From: Amanda Scholes on behalf of Planning.Responses
Sent: 21 November 2018 08:28
To: Planning Scanning
Subject: FW: Planning Consultation on: BE/78/18/RES

Comment from Greenspace

APPLICATION BE/78/18/RES

Description of Works: Approval of reserved matters following
BE/142/15/OUT & BE/113/17/RES for up to 90
No. dwellings regarding layout, landscaping,
appearance & scale.

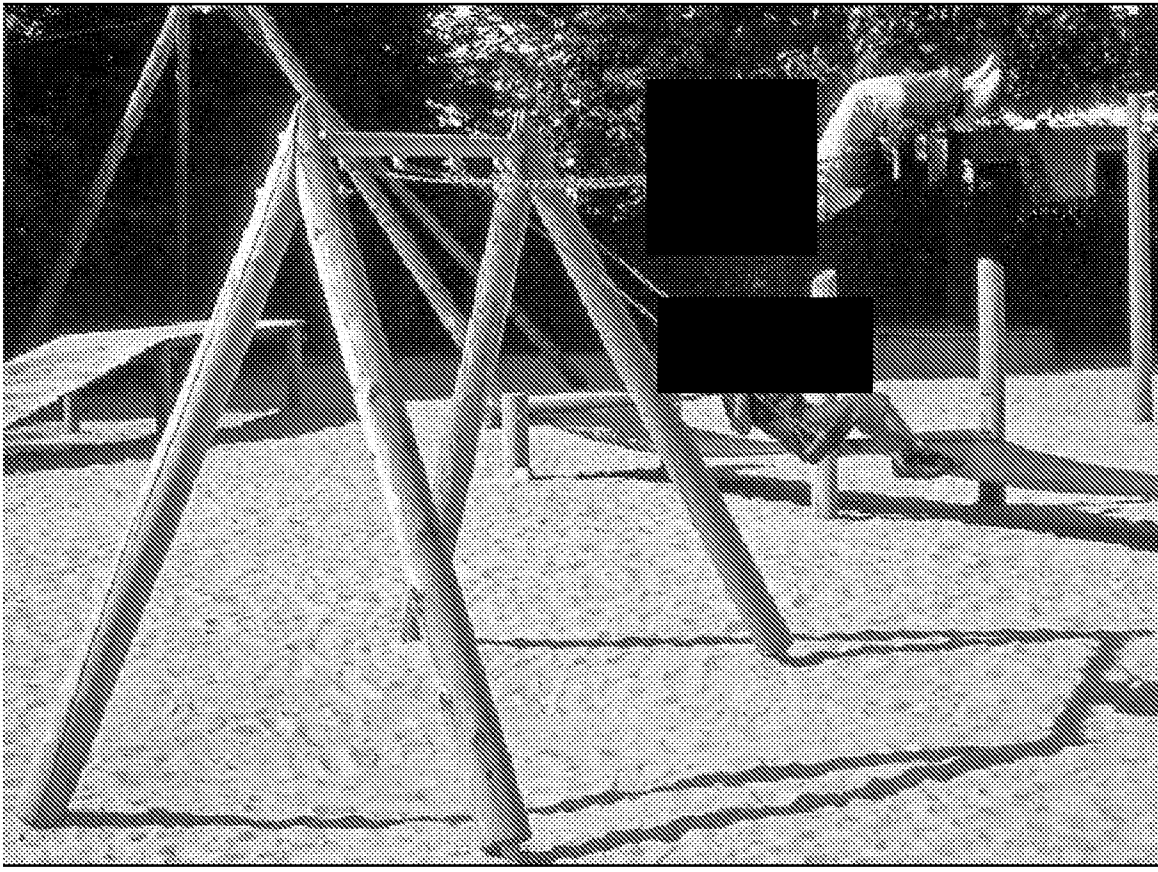
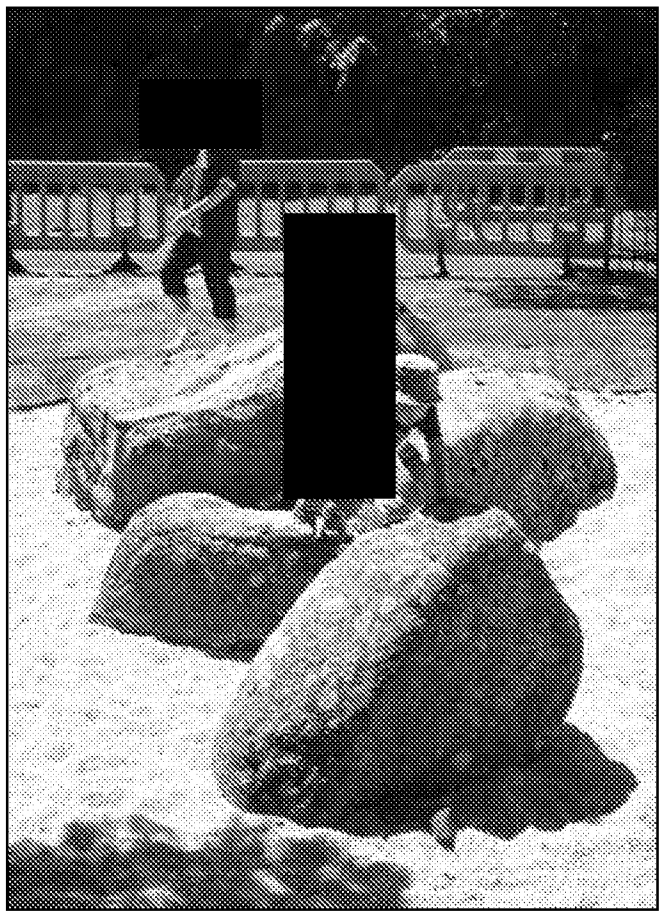
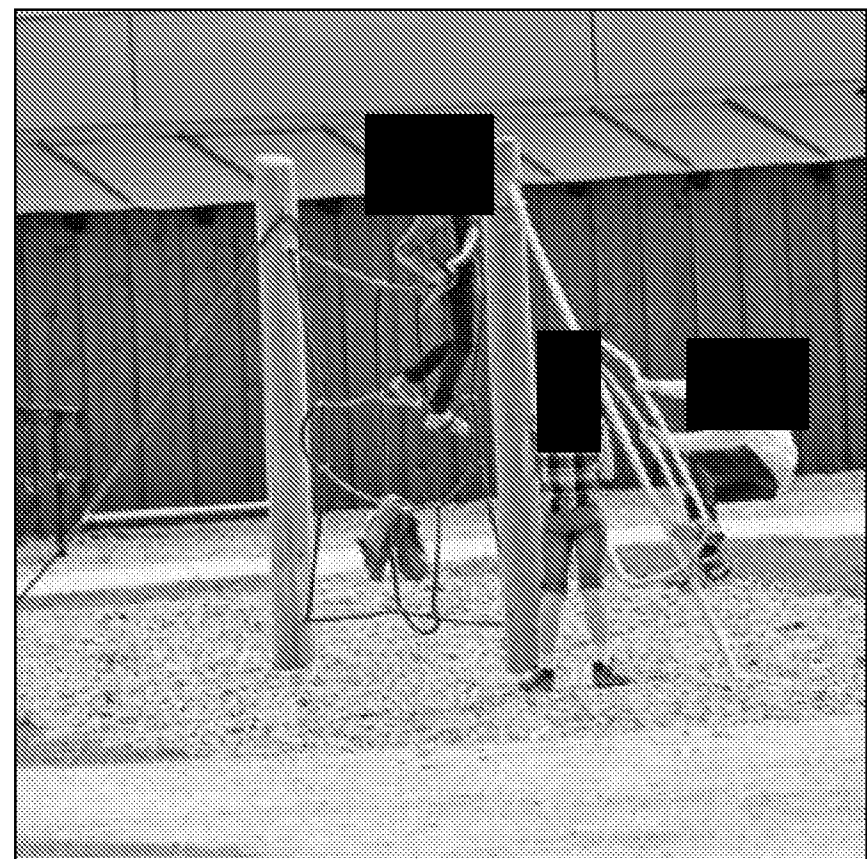
The drawings LIN 2125720 sheets 1&2 Play Area and LIN 21257 21 Open Space, detail primarily the Laps and LEAP detail for this development. The LEAP which is good to see in wooden form, however is lacking in play experiences concentrating on balancing and climbing (as so are the LAPS) which doesn't provide a huge variety in play. This LEAP area would benefit from the inclusion or substitution of equipment to enhance the experiences being provided here.

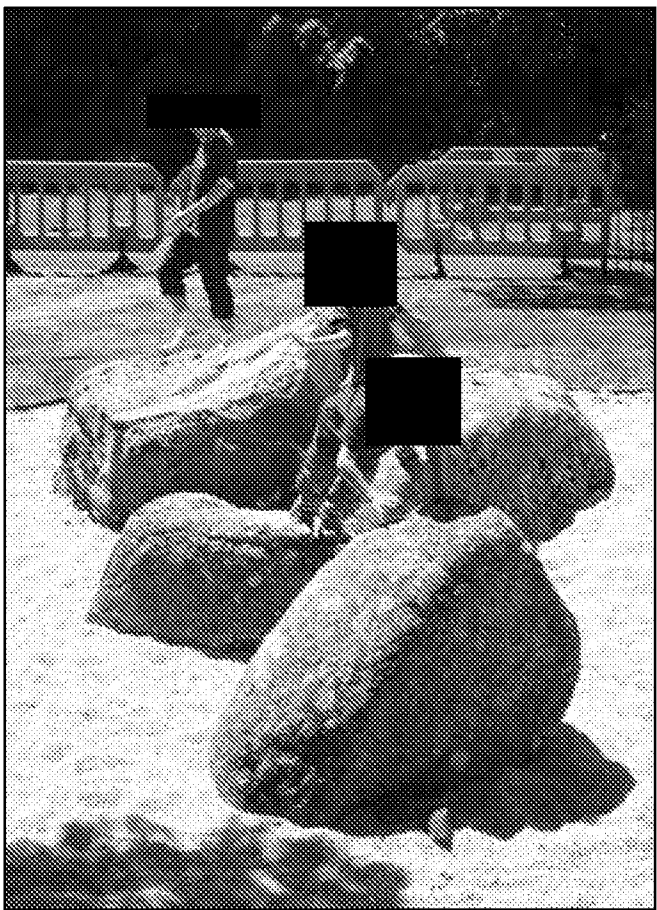
The open space drawing shows a hoggin pathway to the periphery of the play area, this should be changed to a tarmac pathway for durability. There is also no link shown from the pathway to the play area and with the play being bordered with a planted hedge this effectively creates a barrier into the play area, where a gateway for wheeled users leading from the hard pathway would be beneficial rather than having to take a route across the grass.
